ENVIRONMENT AGENCY

COMMENTS ON EXA'S FIRST WRITTEN QUESTIONS

HIGHWAYS ENGLAND'S COMMENTS

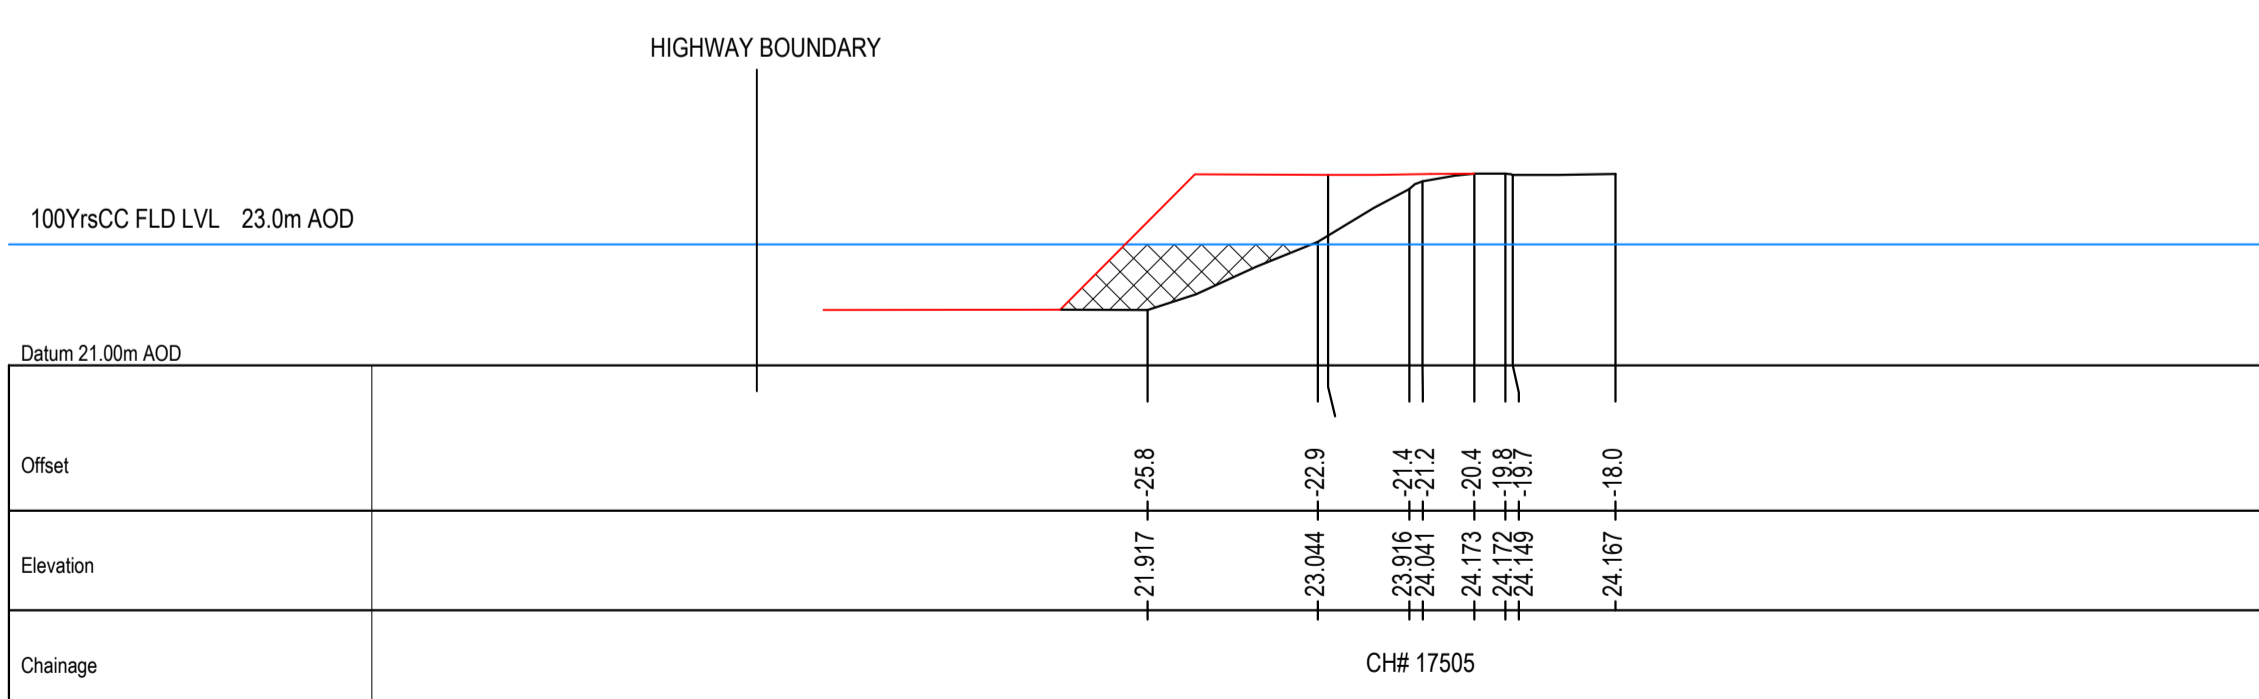
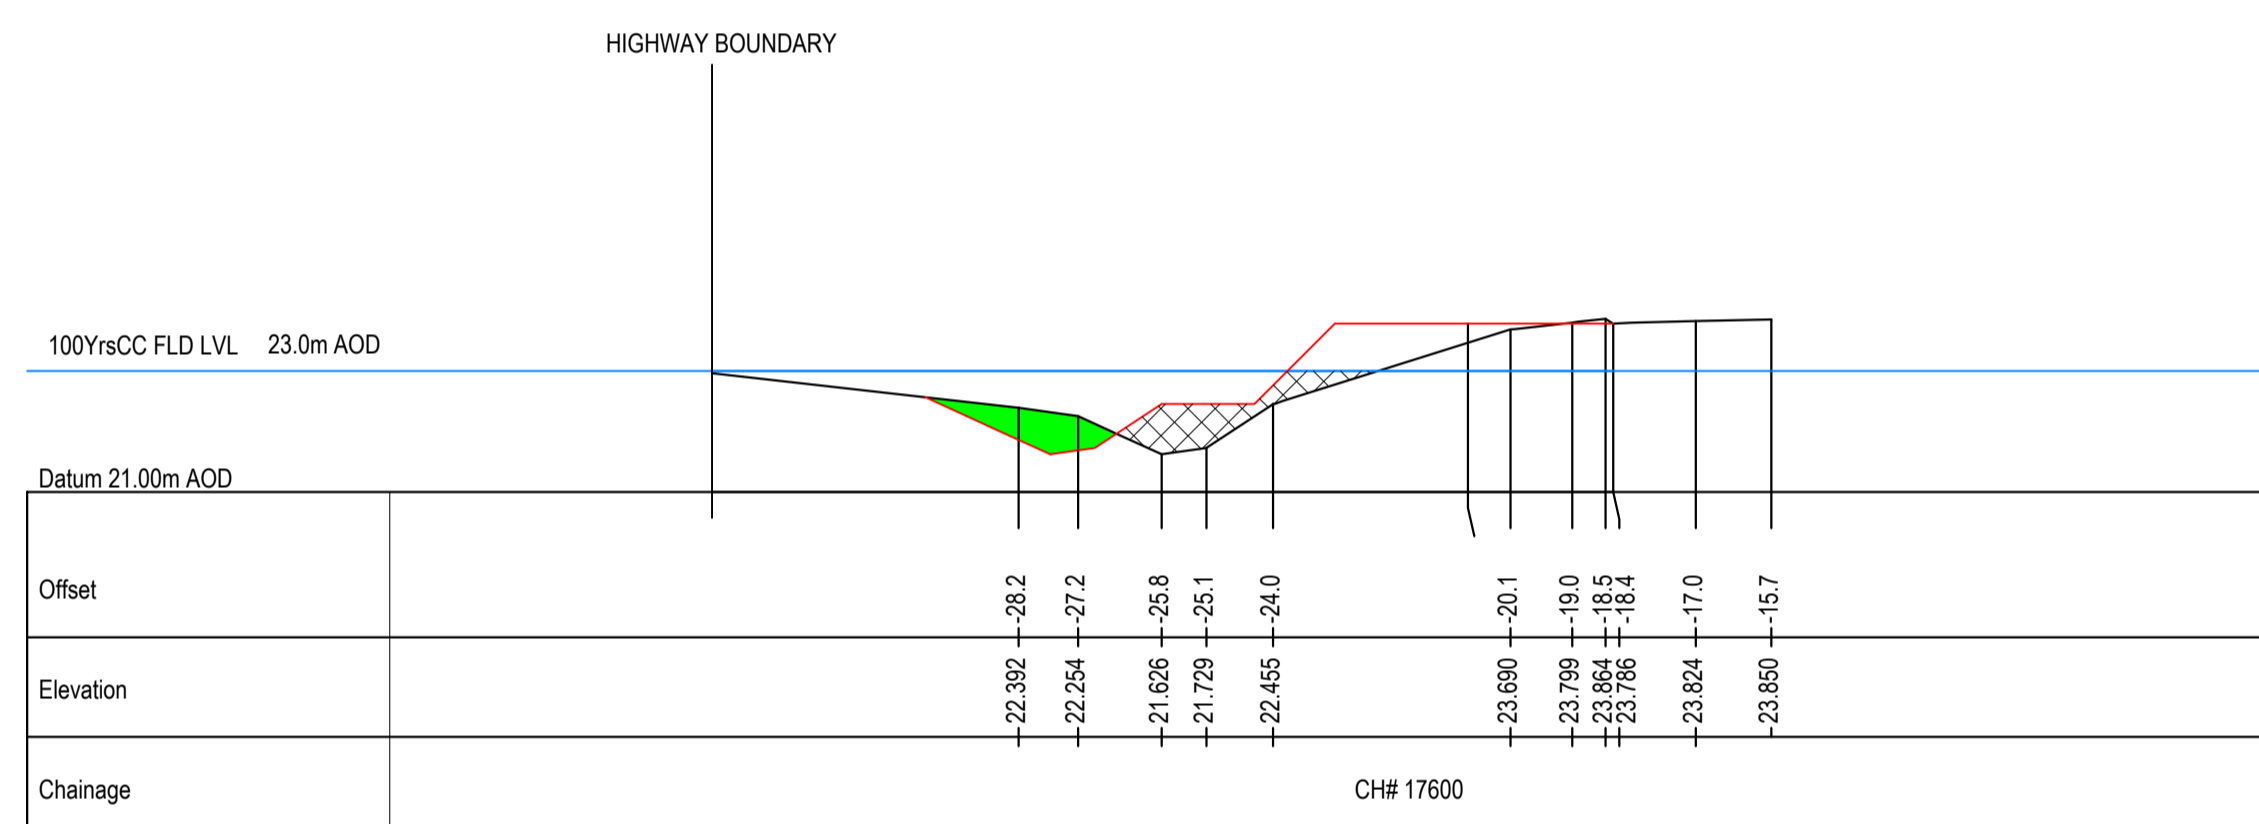
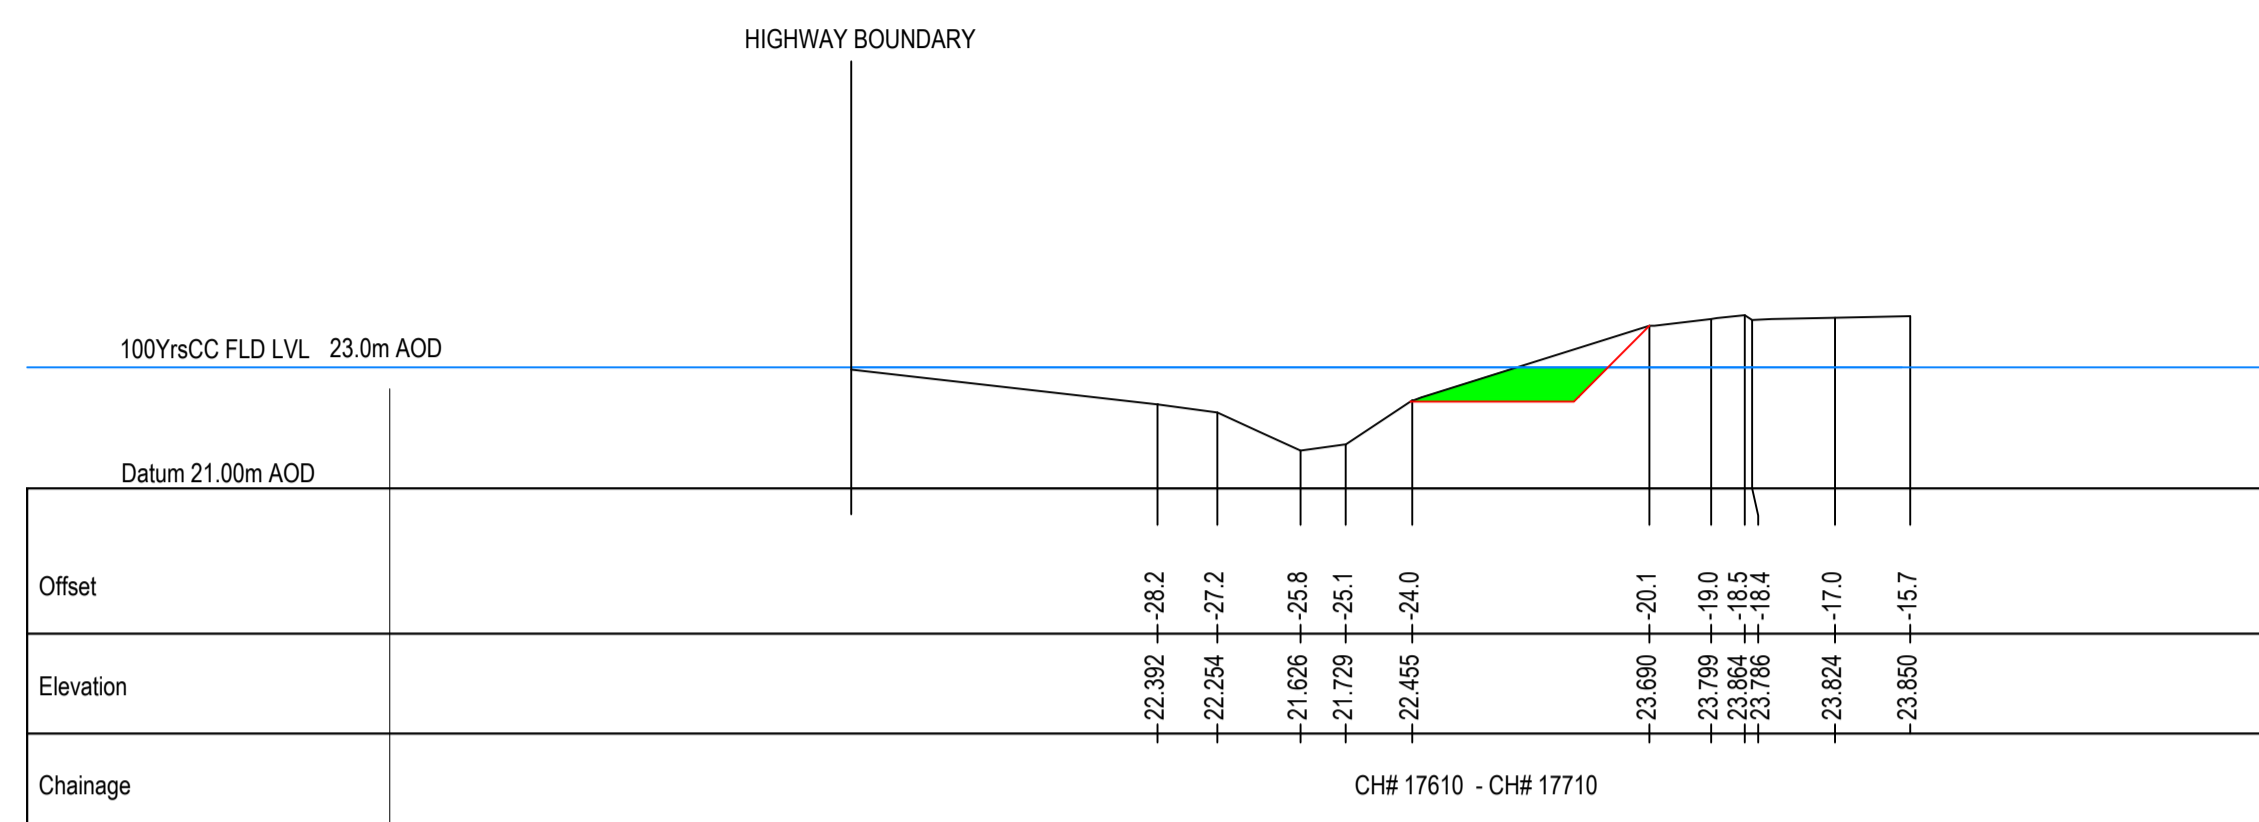
Question Ref	Environment Agency Response	Highways England Comments
	<p><i>The FRA explains that compensation will be provided for and assessed at the detailed design stage. The applicant has suggested that there is the required compensatory storage volume for the proposed earth embankment works but have only supplied volumes. We do not know whether this will be on a level for level basis or volumetric compensation. It could even be provided on a mixture of the two but this is not confirmed. If volumetric compensation is the only option for providing mitigation there could be an increase in flood risk in the higher order events.</i></p> <p><i>The earth embankment work totals 6300m2. It appears that HE are also proposing some small sections of land raising for the Emergency Refuge Areas (ERAs) which is 400m2 per Junction. Without further details about these from the outset, it is unclear if the applicant will be able to satisfactorily provide the required floodplain compensation or how they propose to implement/secure them.</i></p>	<p>As noted above, compensation will be provided as a mix of level for level (at the sites where floodplain storage losses are greatest) and volume for volume.</p> <p>All sites where earth embankment works and widening (such as for the creation of emergency refuge areas (“ERAs”)) have now been identified and confirmed within an updated FRA, which has also demonstrated (with the exception of works within the River Loddon floodplain, which Highways England are still awaiting Environment Agency flood level data for) that the required floodplain compensation can satisfactorily be provided. This mitigation will be secured by the inclusion of a further requirement in the DCO regarding the provision of flood compensation, as explained above.</p>

Question Ref	Environment Agency Response	Highways England Comments
	<p><i>compensation. It could even be provided on a mixture of the two but this is not confirmed. If only volumetric compensation is used to mitigate there could be an increase in flood risk in the higher order events.</i></p> <p><i>The earth embankment work totals 6300m2. It appears that HE are also proposing some small sections of land raising for the Emergency Refuge Areas (ERAs) which is 400m2 per Junction.</i></p> <p><i>Without further details from the outset, it is unclear if the applicant will be able to satisfactorily provide the required measures or how they propose to implement/secure them through the DCO, phasing schemes and other associated documents.</i></p> <p><i>At the time of writing we are waiting for further flood risk information and evidence to be provided by the applicant for consideration and review. Upon receipt of this information we will notify the ExA if our position has changed and/or appropriate mitigation measures have been agreed.</i></p>	<p>As stated above, all sites where earth embankment works and widening (such as for the creation of ERAs) have now been identified and assessed within an updated FRA, which has also demonstrated (with the exception of works within the River Loddon floodplain, which Highways England are still awaiting Environment Agency flood level data for) that the required floodplain compensation can satisfactorily be provided. This mitigation will be secured by the inclusion of a further requirement in the DCO in relation to flood compensation, which is reflected in the latest draft DCO submitted at Deadline III to cover this aspect.</p> <p>Compensation will be provided on a mixed level for level (at the sites where floodplain storage losses are greatest) and volume for volume basis and compensation solutions at individual sites of loss would be further developed during the detailed design stage of the Scheme. This mitigation will be secured by the inclusion of a further requirement in the DCO regarding the provision of floodplain compensation.</p> <p>Highways England confirms that there is ongoing dialogue with the Environment Agency regarding its concerns. Additional information was provided to the Environment Agency following a meeting on the 25th September 2015. That information was discussed at a meeting with the Environment Agency on 28th October 2015.</p>
